Re: Customer Reference No 6518327617 pre-connection enquiry - Subject to contract | Contract denied [Connection for 354 domestic units and a creche]

Re: Design Submission for Oldtown, Swords, Dublin (the "Development") (the "Design Submission") / Connection Reference No: CDS21001700

We have reviewed your proposal for the connection(s) at the Development. Based on the information provided, which included the documents outlined in Appendix A to this letter, Irish Water has no objection to your proposals.

- [17-144-P1201]
- [17-144-P1202]
- [17-144-P1203]
- [17-144-P1301]
- [17-144-P1302]
- [17-144-P1303]
- [17-144 Foul Long Section (Foul 1)]
- [17-144 Foul Long Section (Foul 2)]
- [17-144 Foul Long Section (Foul 3)]

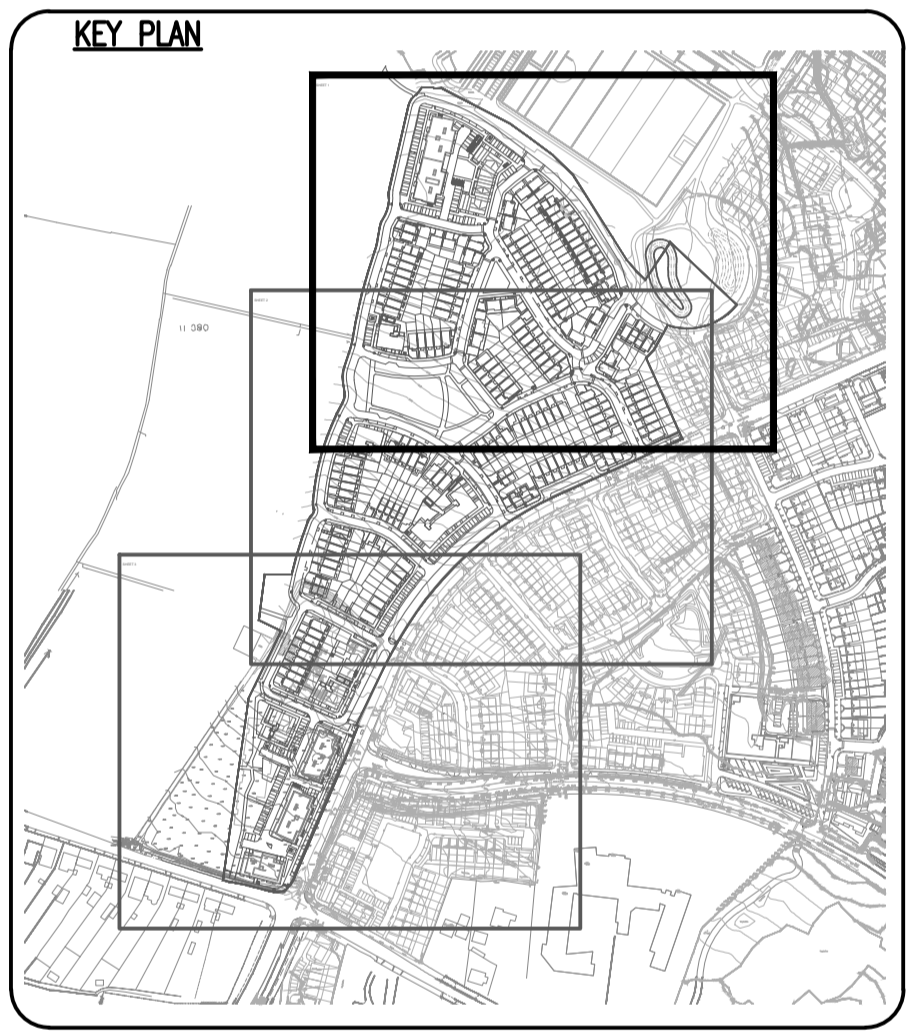
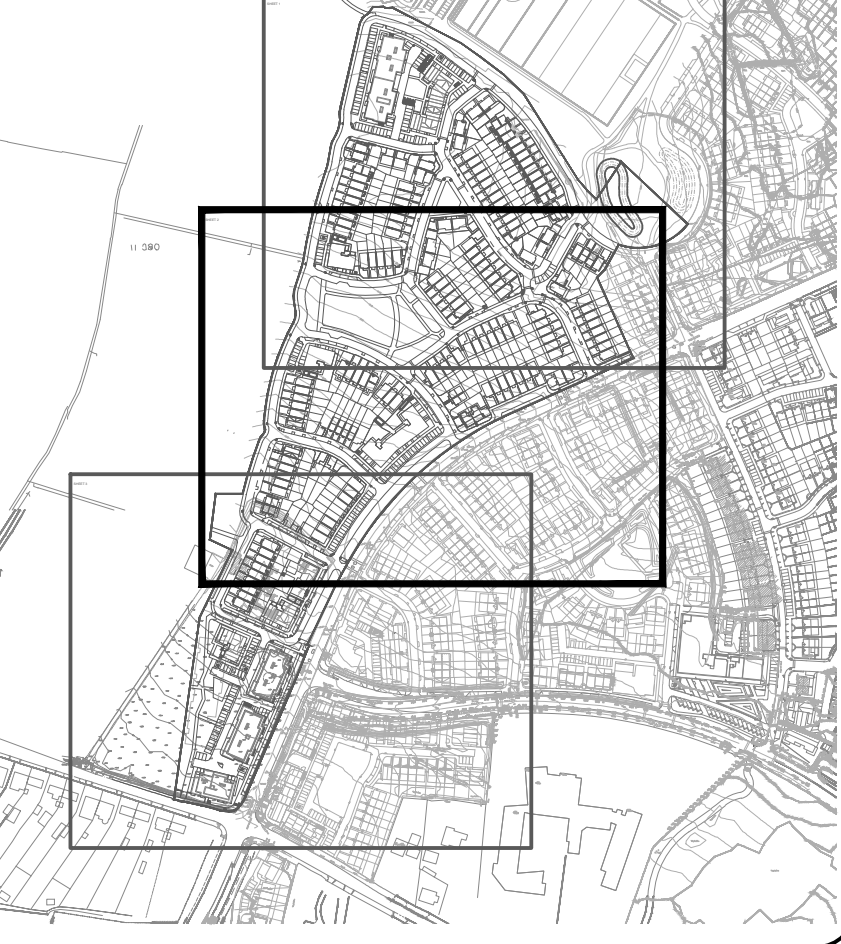
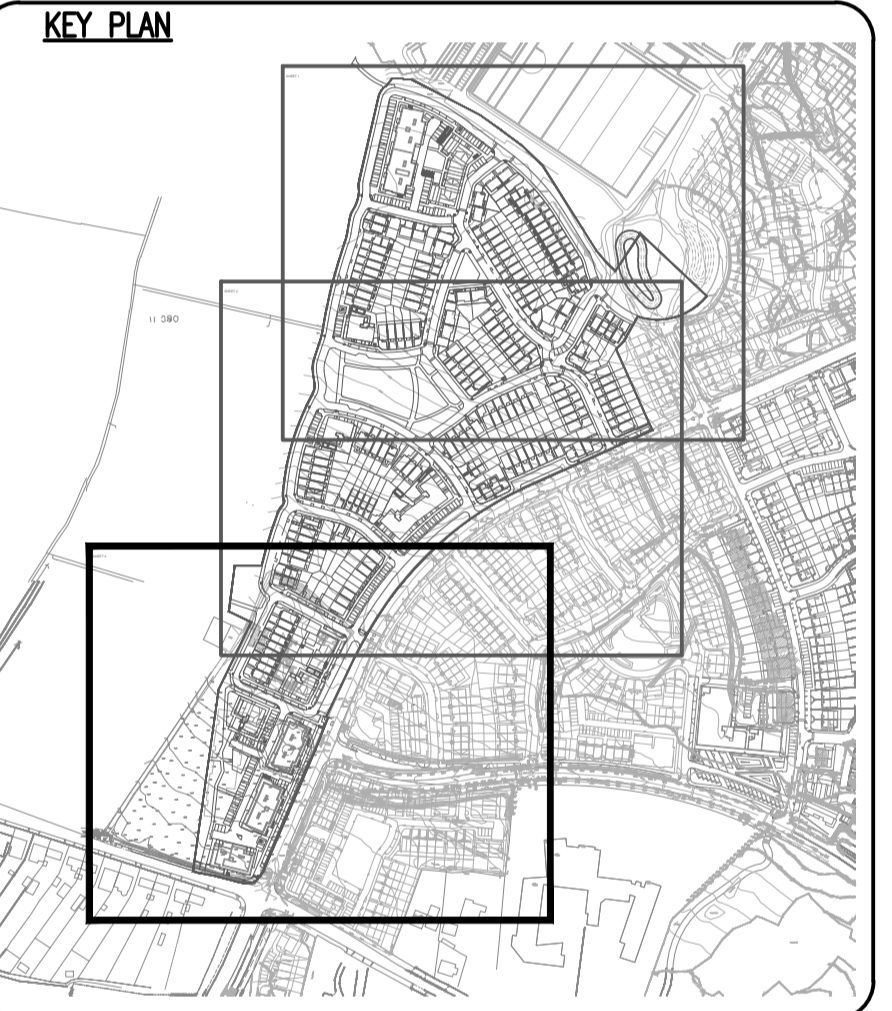
While Irish Water notes that the apartment block wastewater collector infrastructure will remain private and not be vested, we have the following comments:

• It is recommended that the apartment block wastewater collectors should be located 3m distance from the apartment block.
